**Re: Sunport Apartments  
2930 Mulberry SE  
Request for Certificate of Occupancy  
Transportation Development Final Inspection**  
Architect's Stamp dated 07-07-20 (M15-D036)  
Certification dated 09-30-22

Based upon the information provided in your submittal received 10-04-22, Transportation Development cannot approve the release of Certificate of Occupancy for the above referenced project.

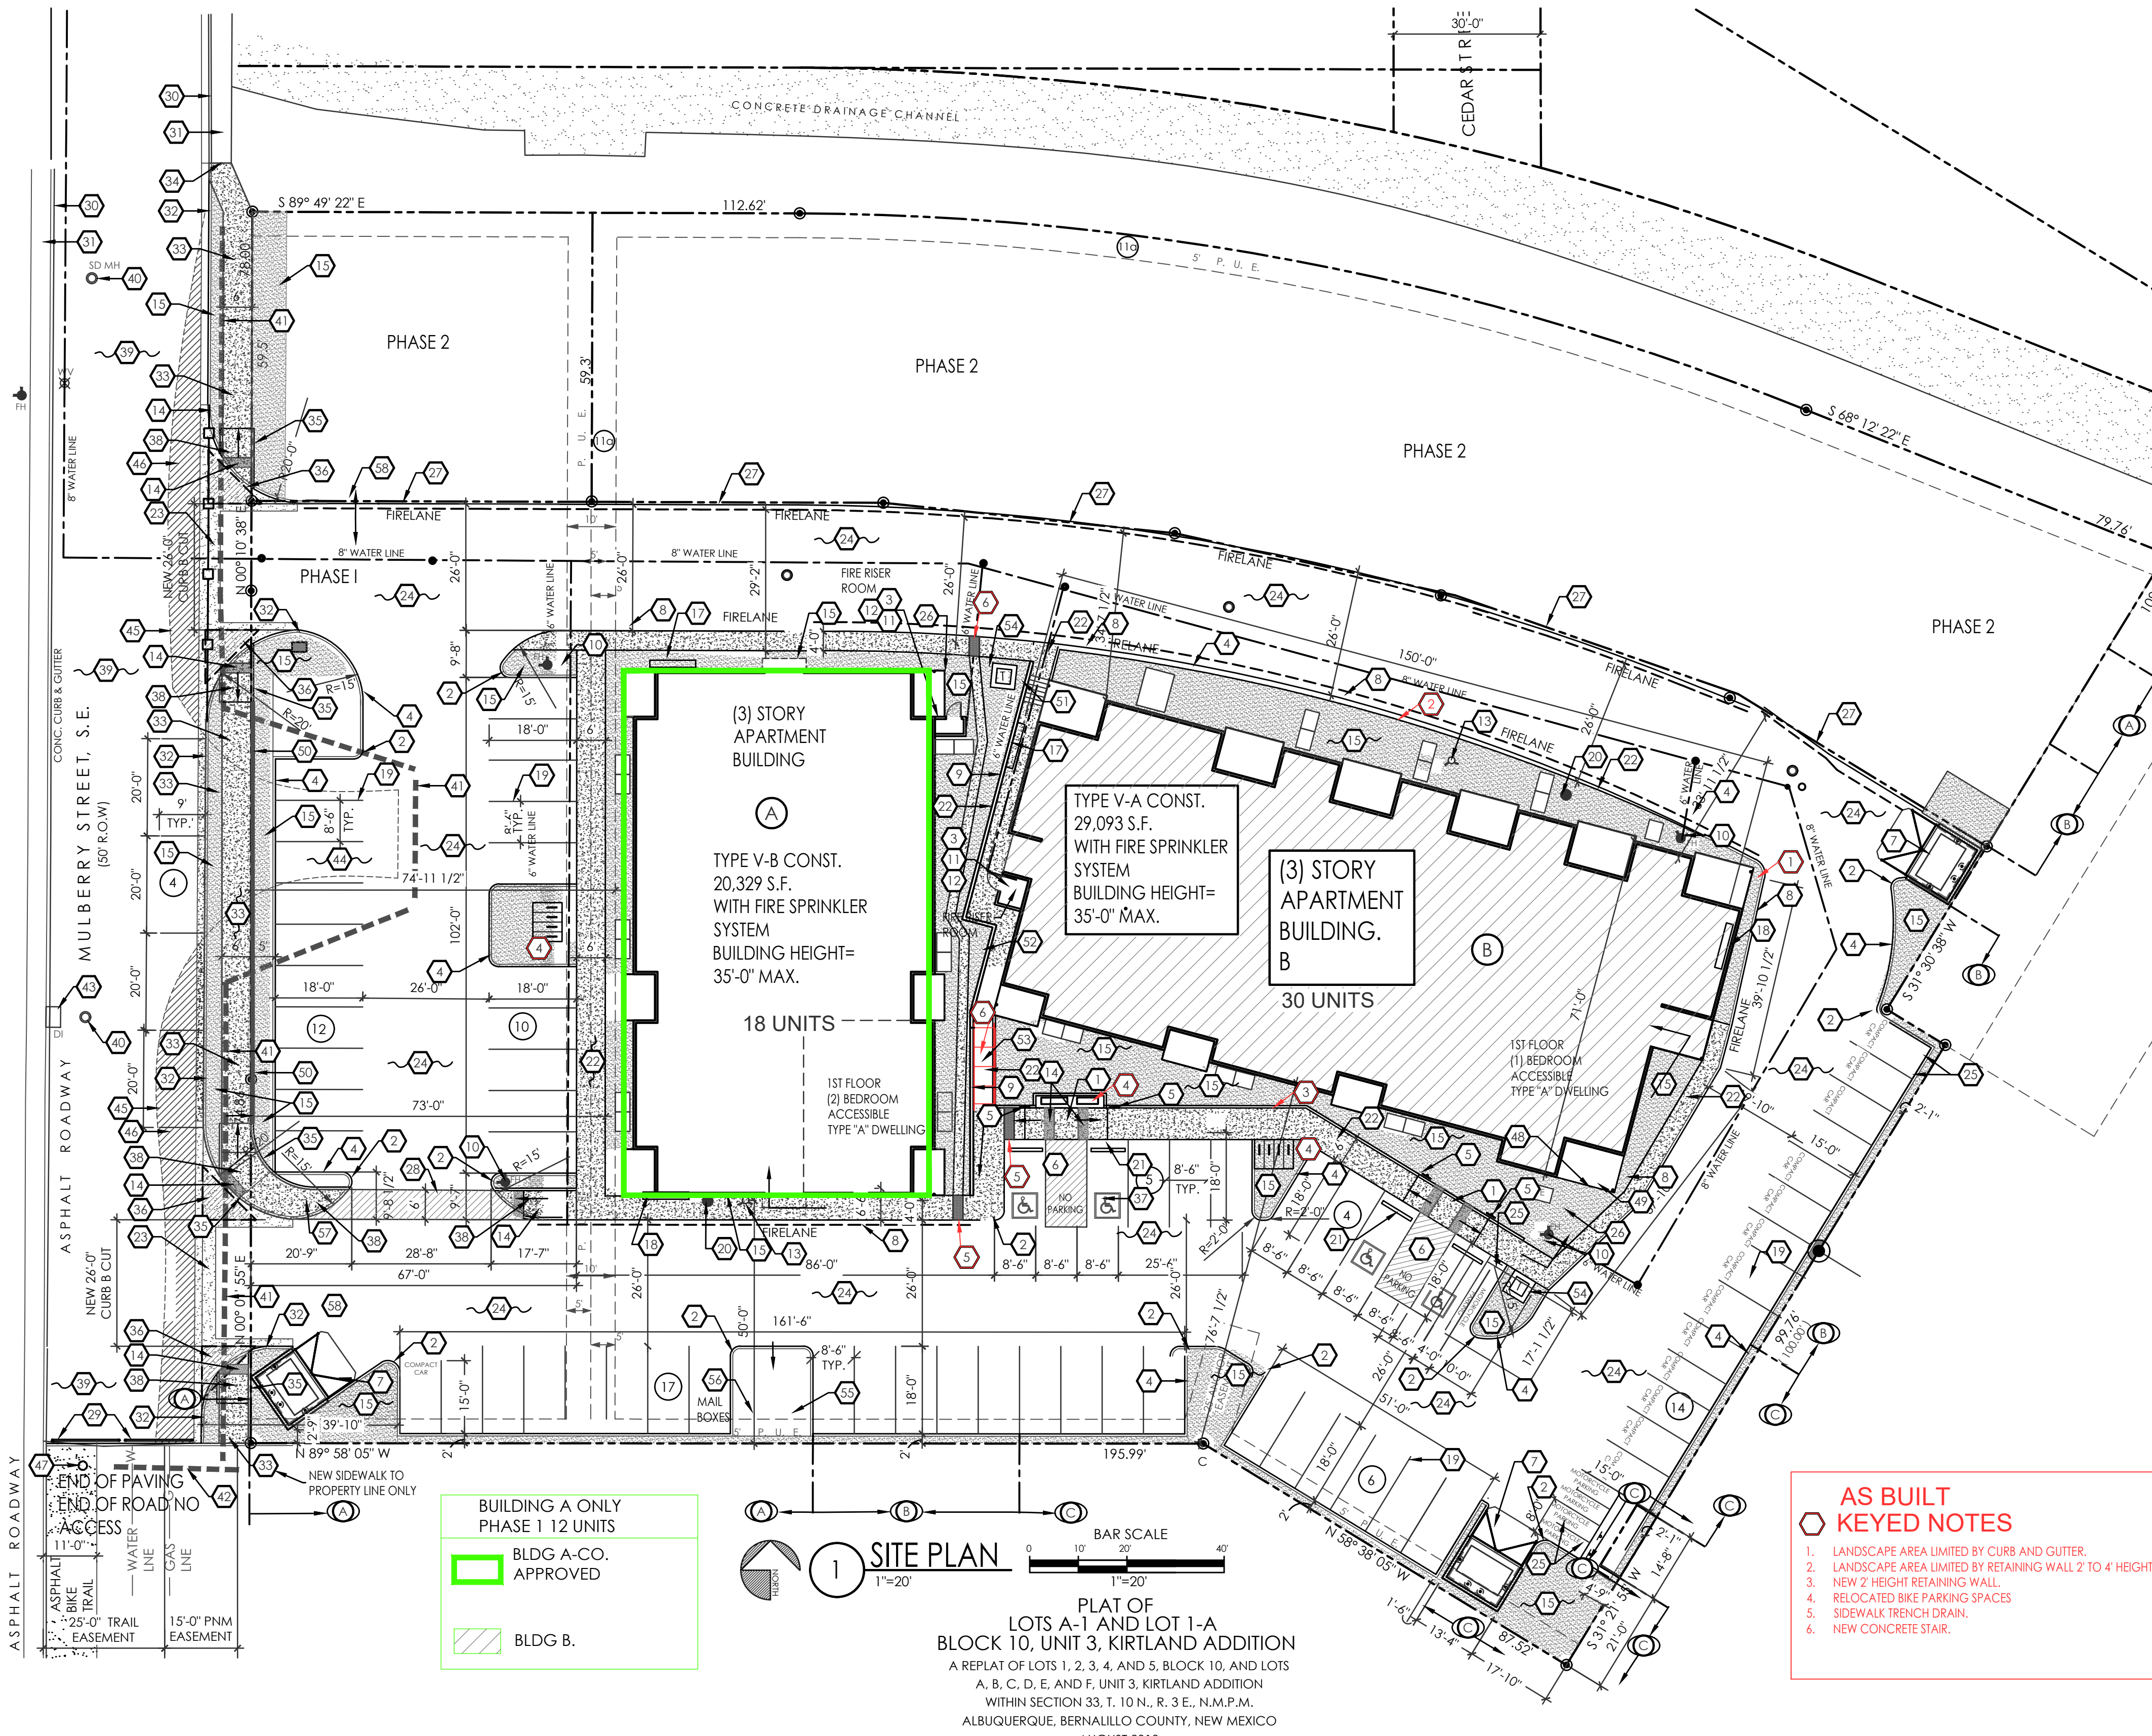
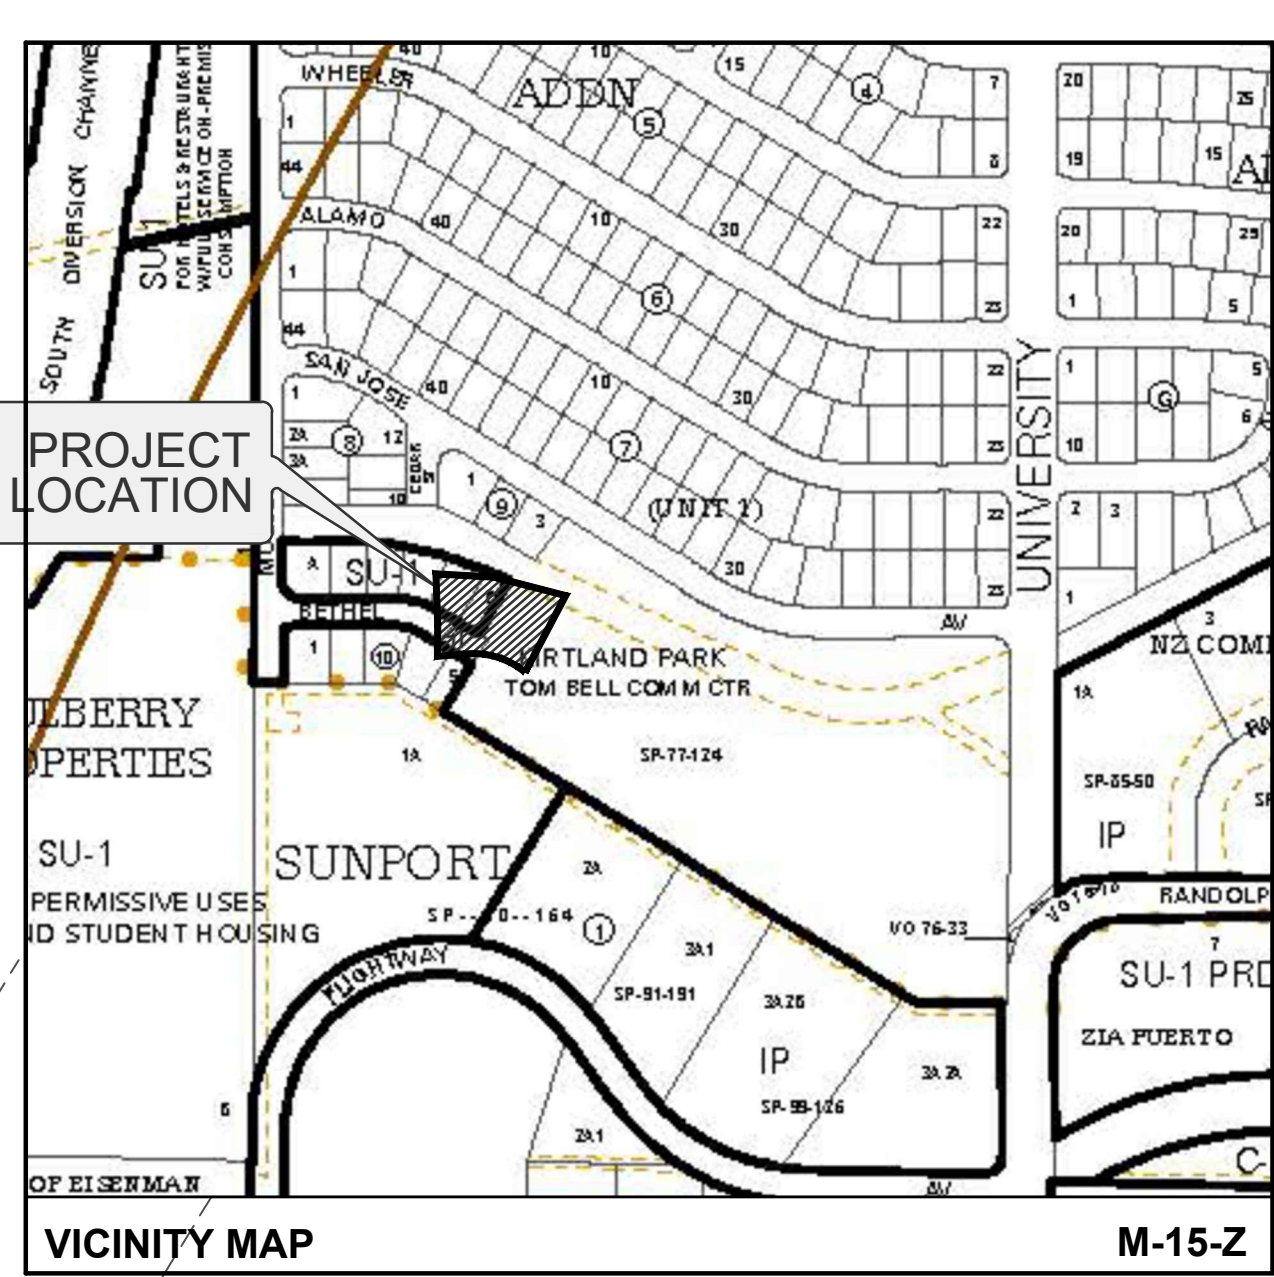
- Work order must be completed, approved and accepted by City of Albuquerque.
- Please finish the site work at the north side of the site.
- Key note 53: Per site visit, ADA ramp leads to a step, which is not acceptable. Per approved site plan the ADA pathway should lead to the building entrance. Please address this concern. See attached picture.
- Label the compact parking spaces by placing the words "**COMPACT**" on the pavement of each space.
- The pavement marking "MC" should be shown in the opposite direction for motorcycles entering the parking space.
- Please provide Van signage for one of the ADA parking spaces.
